**From:** Jeff Rice <JeffRice@elpasoco.com>  
**Sent:** Tuesday, May 25, 2021 5:45 PM  
**To:** Fitzpatrick, Raimere <Raimere.Fitzpatrick@kimley-horn.com>  
**Cc:** Kari Parsons <kariparsons@elpasoco.com>; Elizabeth Nijkamp <ElizabethNijkamp@elpasoco.com>  
**Subject:** Upland Flats By Watermark Filing No. 1

I don't see a comment response letter to this submittal and just need a response to one comment: **the TIS states that "removal or restriction of the southern access is not expected to significantly change the operations of the Hunter Jumper Drive and Akers Drive intersection". Based on this and the limited amount of traffic that would use the right-out, would a right-in only at the proposed second access be acceptable to the developer?**

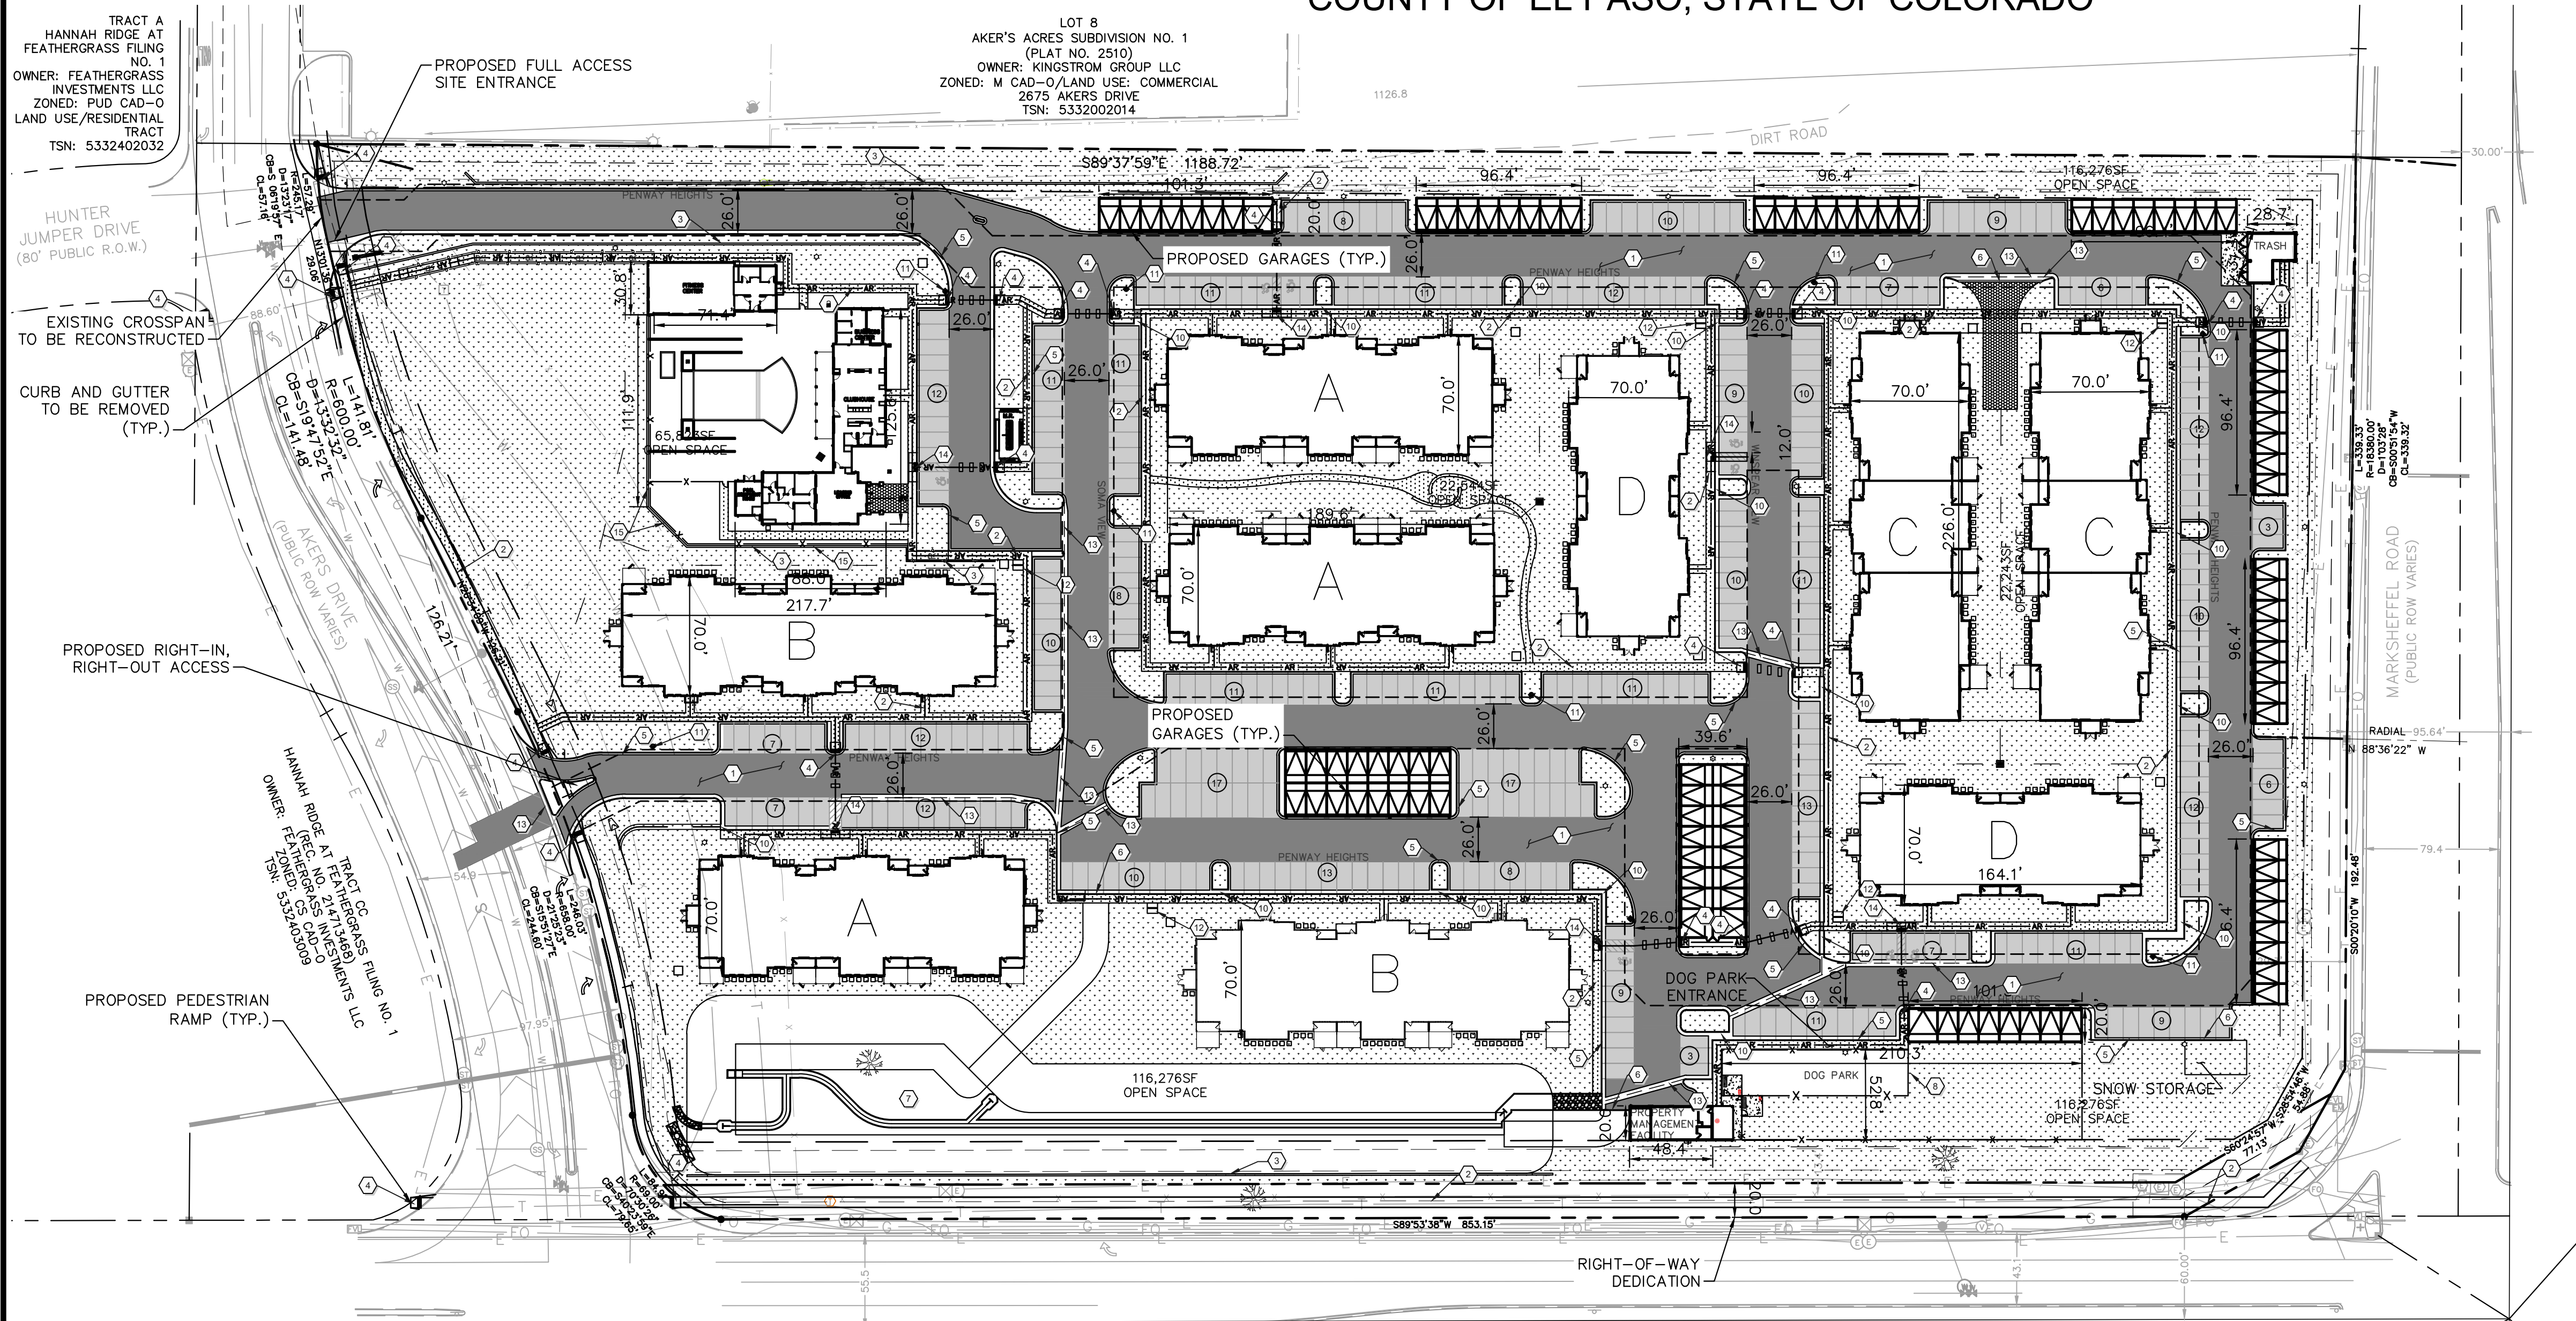
As we discussed last Thursday, if the developer really wants the right-out (together with the right-in) on Akers we will most likely require a license agreement addressing requirements if the access point becomes a safety issue.
